RE: REVIEW OF CHAIN VALLEY COLLIERY – MODIFICATION 1 ENVIRONMENTAL ASSESSMENT – SECTION 96 MODIFICATION TO SSD-5465

ATTACHMENT 1: COMMENTS AND RECOMMENDED CONDITIONS OF APPROVAL FOR PROPOSED CHAIN VALLEY COLLIERY – SECTION 96 MODIFICATION TO SSD-5465

Figure 3: Proposed linkage in relation to existing workings and surface features

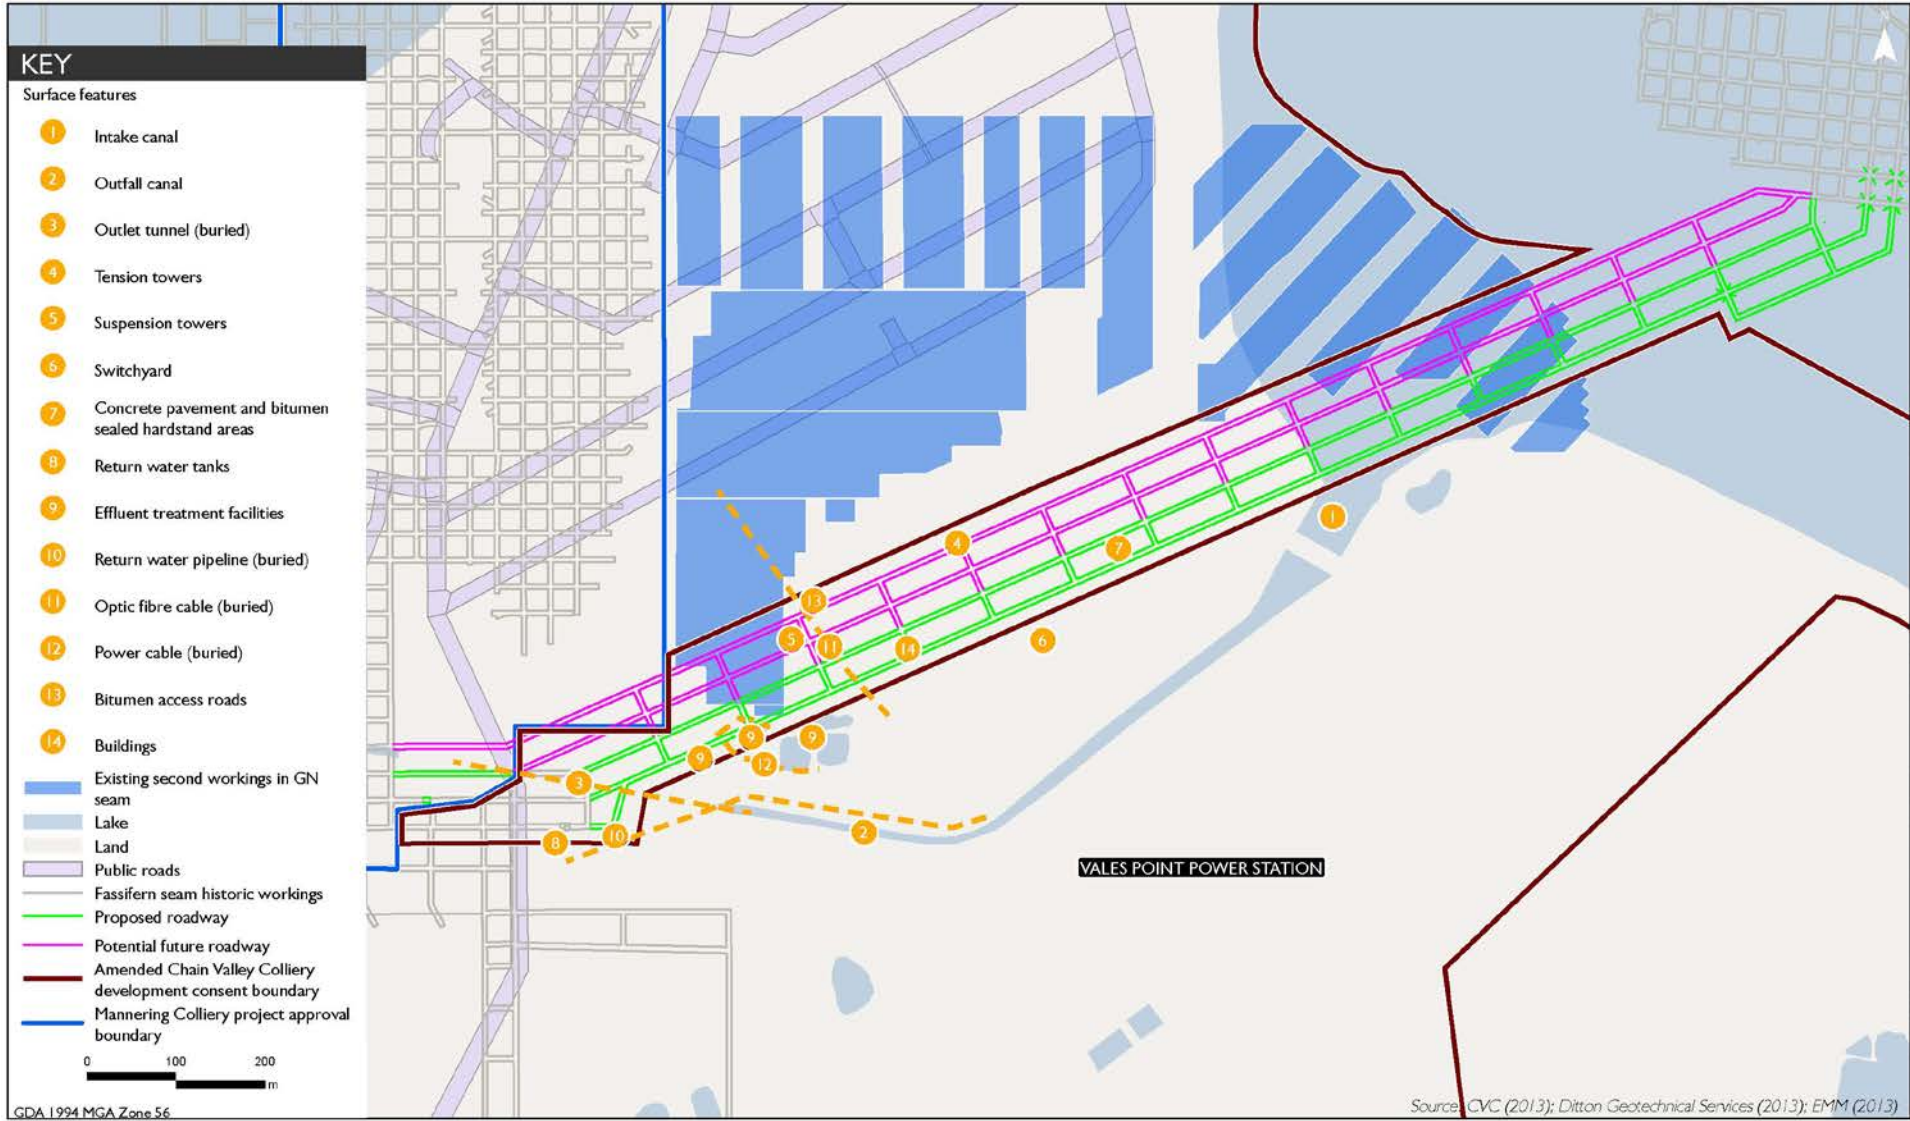
OEH has reviewed the EA for potential impacts on the benthic ecology of the bed of Lake Macquarie in the modification area and due to the lack of information is unable to assess this application. OEH acknowledges that predicted subsidence from the proposed underground linkage will range from 5 mm to 20 mm where first and secondary working occurs, respectively. Nonetheless OEH is of the opinion that the EA does not adequately assesses the impacts of subsidence on the benthic micro and macro communities in Lake Macquarie and has concerns about the location of the highest predicted levels of subsidence and therefore cumulative subsidence corresponding with the shoreline and the Seagrass Protection Barrier.

OEH has concerns about any changes in depth in the lake due to mine subsidence that may reduce light levels reaching the sediment surface and thereby affect benthic microalgal primary production. Subtle changes in depths influencing critical light levels reaching the sediment surface can have strong effects on benthic productivity and this can have flow on effects to important ecological processes such as oxygen production and sediment-water nutrient cycling.
